CUDLOW AVENUE FREEHOLDERS ASSOCIATION (CAFA)

Re: Planning Permission Application Ref:- R/184/17/PD (Change of use of shop to restaurant/café)

We are writing further to the planning permission recently submitted for the 'change of use' of No 51 Sea Lane, Rustington, from a shop to a restaurant/café.

**APPENDIX ONE:
DRAWING SHOWING EXTERNAL EXTRACT AND VENTILATION EQUIPMENT PROPOSED**

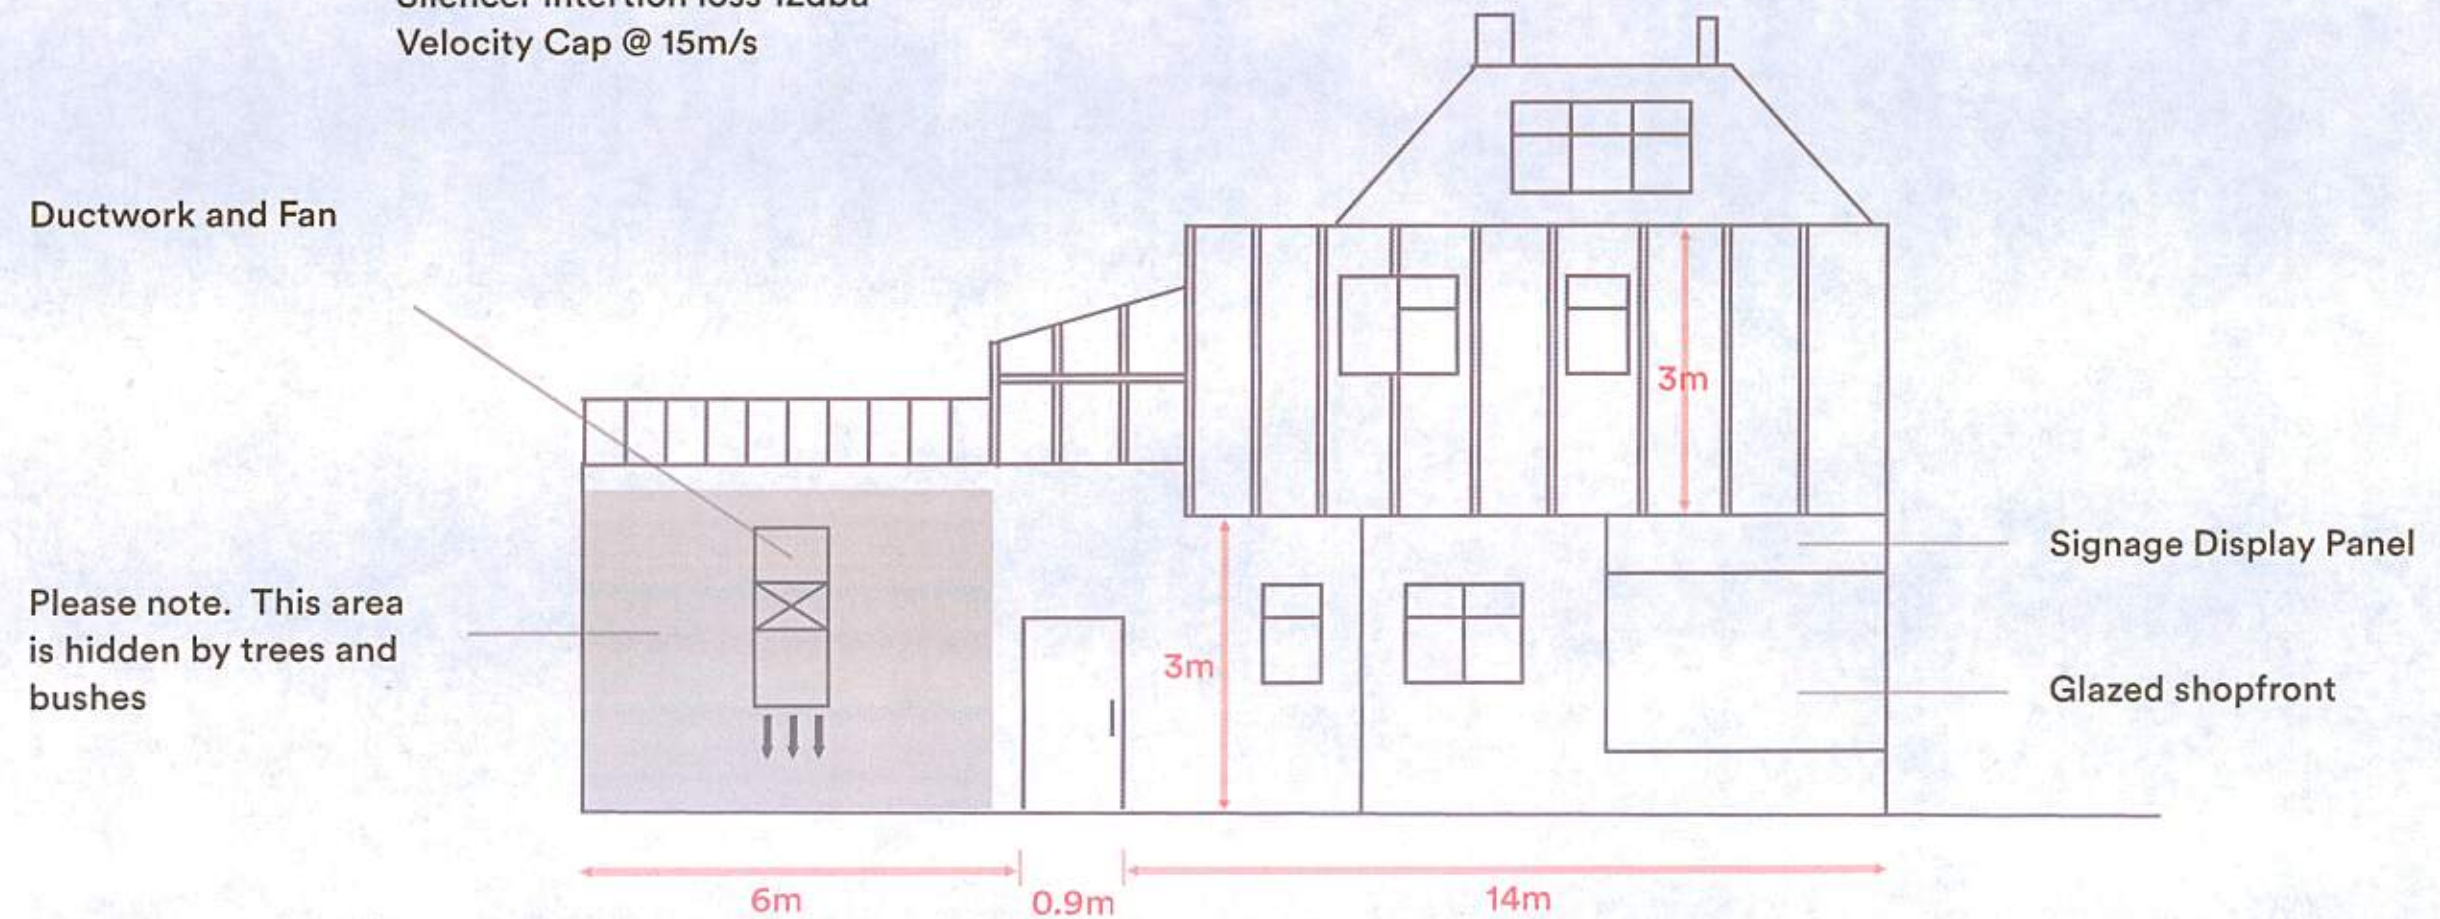
Ventilation. The plans for the kitchen at this property show there are no windows for ventilation which will mean the back door will be open to allow fresh air for kitchen staff and for them to take their breaks. We believe this will have an impact on the appearance of this private road.

We believe from the plans that the proposed extractor fan will cause noise, and smells which again will impact the residents especially the two listed buildings opposite this property.

APPENDIX TWO:
DRAWING SHOWING PROPOSED REFUSE FACILITIES

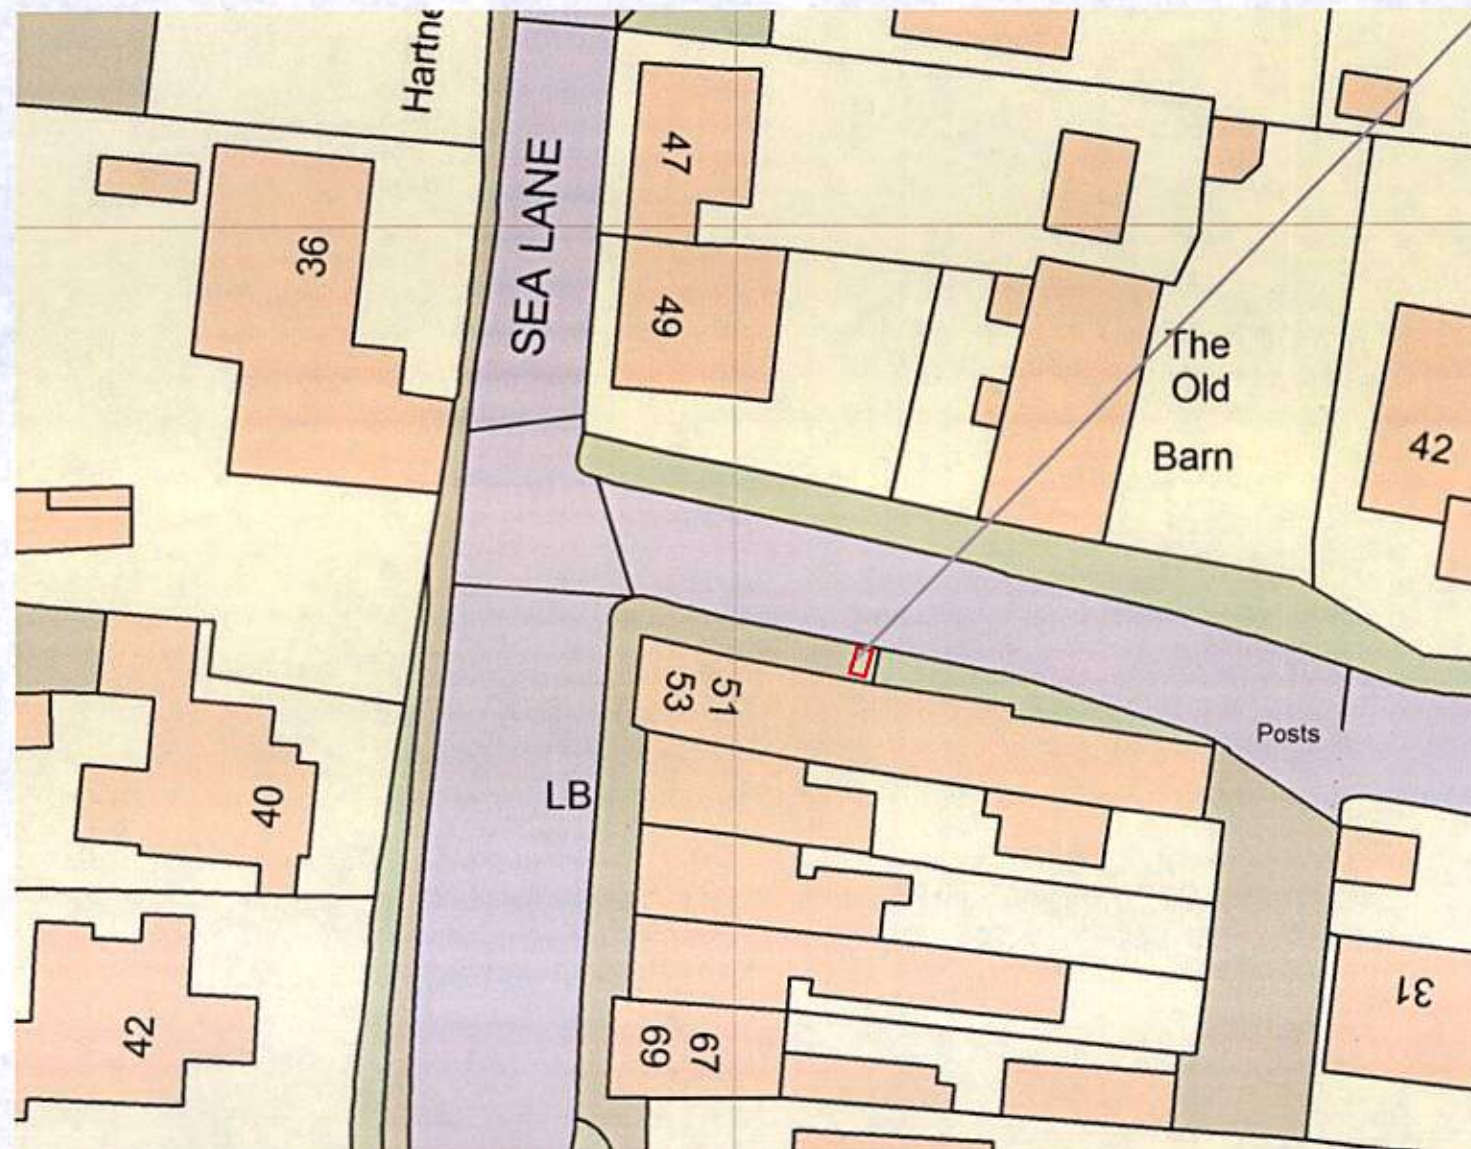
Vermin. There is already a serious vermin problem in this area and we believe that further food waste will encourage this nightly disturbance and nuisance in the area. There are large numbers of foxes causing damage in the area to property, gardens and domestic pets.
